Your Ref
AB/8/12/
Our Ref
S/AR/2012/8
Date
02/03/2012

Proposal: Erection of 1 no. new dwelling.
Site: Land adj 84 Maltravers Street, Arundel, BN18 9DS.
AB/8/12/

SOUTHERN WATER

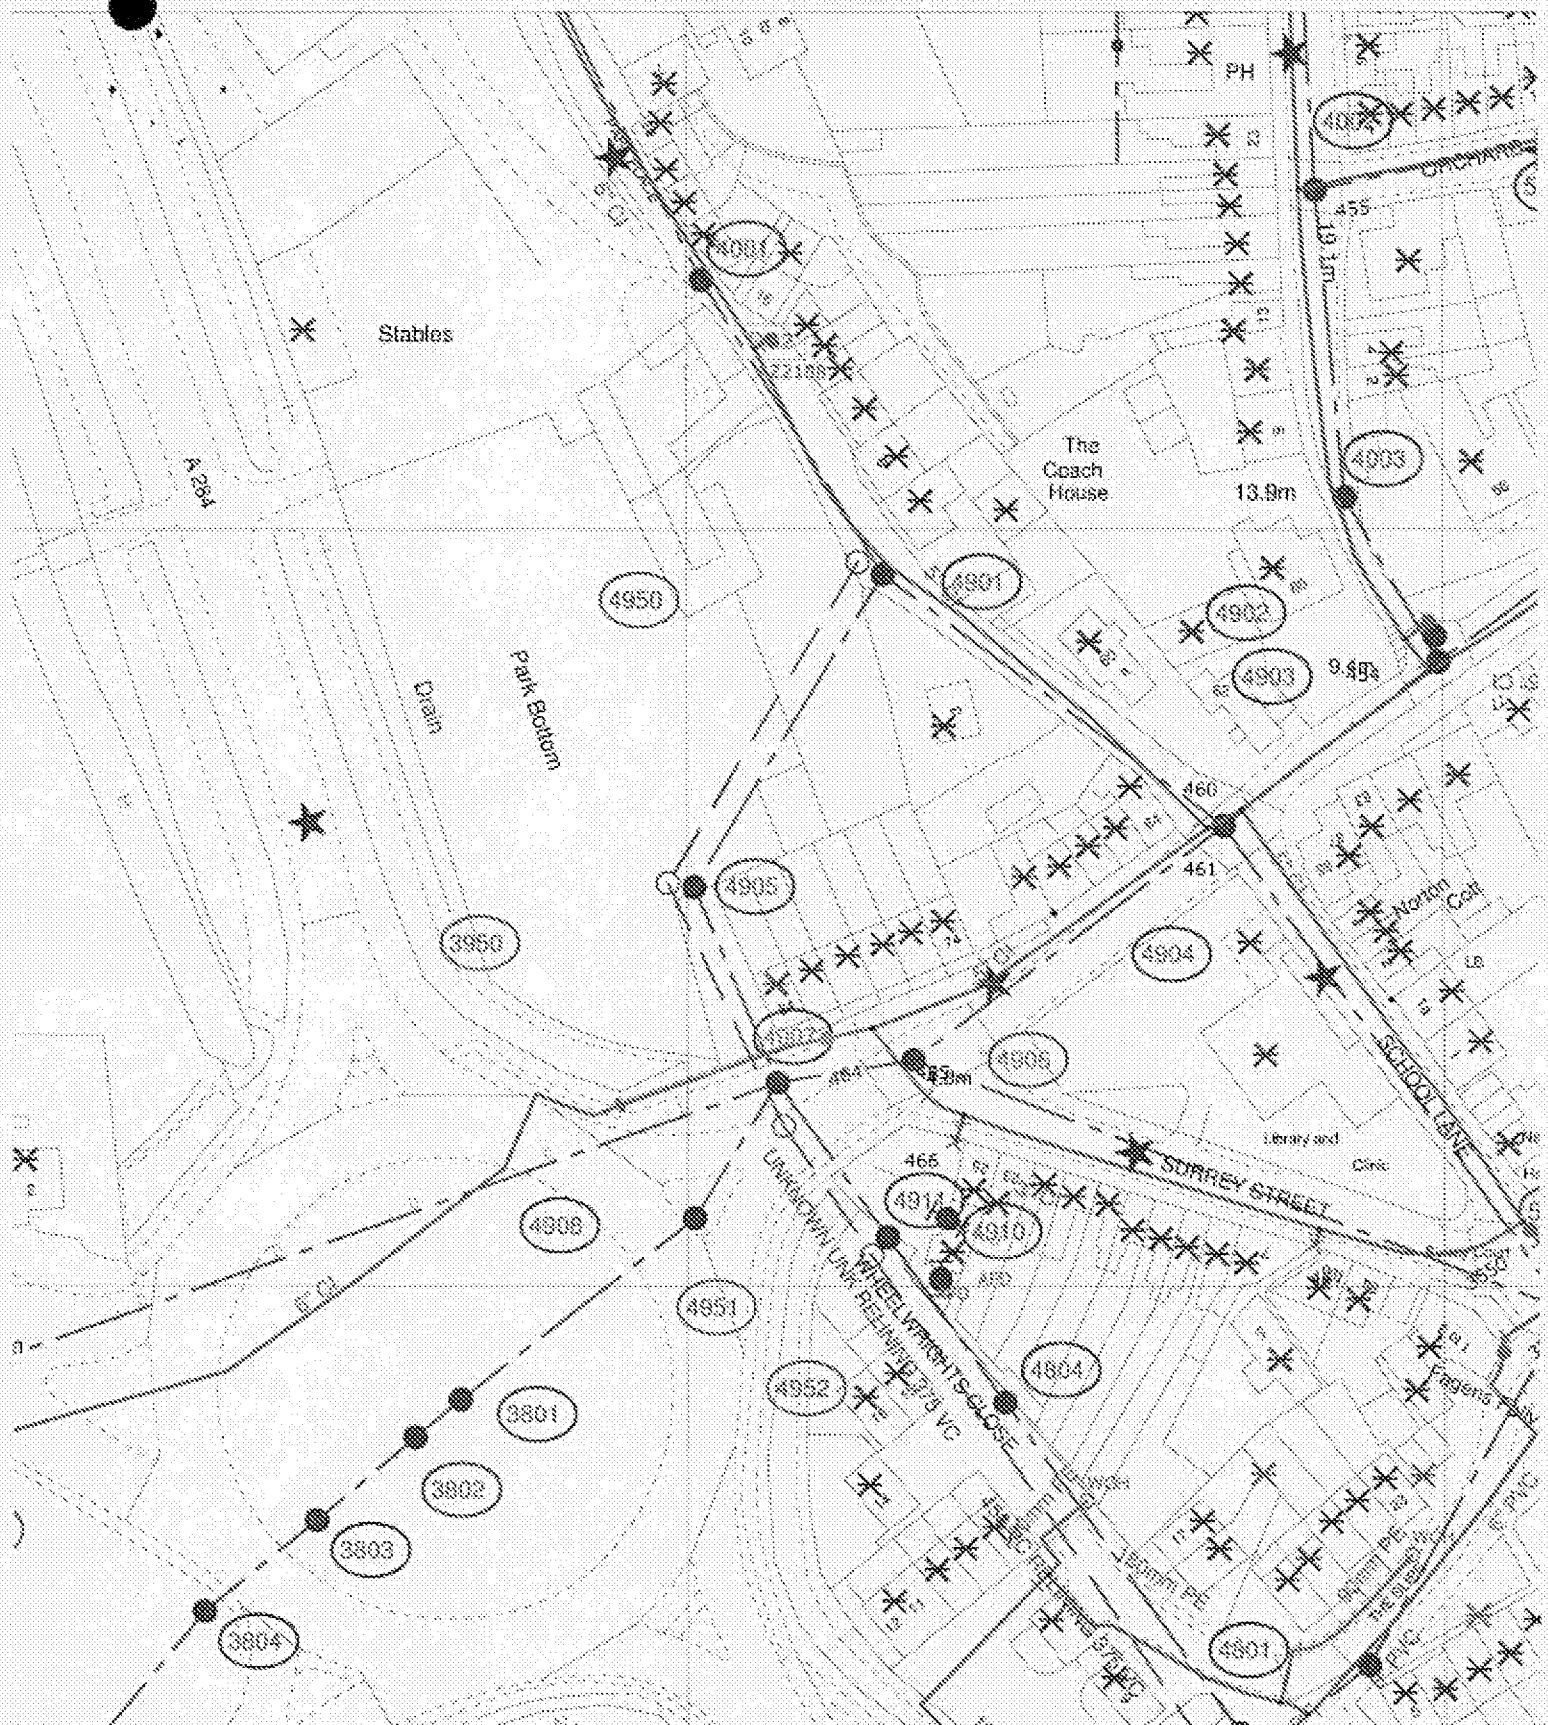
Please find attached a plan of the sewer records showing the approximate position of a foul and surface water sewer crossing the site. The exact position of the foul and surface water sewer must be determined on site by the applicant before the layout of the proposed development is finalised.

1. The 225 mm diameter foul sewer requires a clearance of 3 metres either side of the foul sewer and the surface water sewer requires a clearance of 3 metres either side of 375mm surface water sewer, to protect it from construction works and allow for future access for maintenance.
2. No development or new tree planting should be located within 3 metres either side of the centreline of the foul and surface water sewers.
3. No new soakaways should be located within 5 metres of a foul and surface water sewer.
4. All other existing infrastructure should be protected during the course of construction works.

It might be possible to divert the foul and surface water sewer, so long as this would result in no unacceptable loss of hydraulic capacity, and the work was carried out at the developer's expense to the satisfaction of Southern Water under the relevant statutory provisions. If the sewers cannot be diverted under a section 185 sewer diversion application, Southern Water issue an objection notice for the above proposal.

Alternatively, the applicant may wish to amend the site layout, or combine a diversion with amendment of the site layout. If the applicant would prefer to advance these options, items (1) – (4) above also apply.
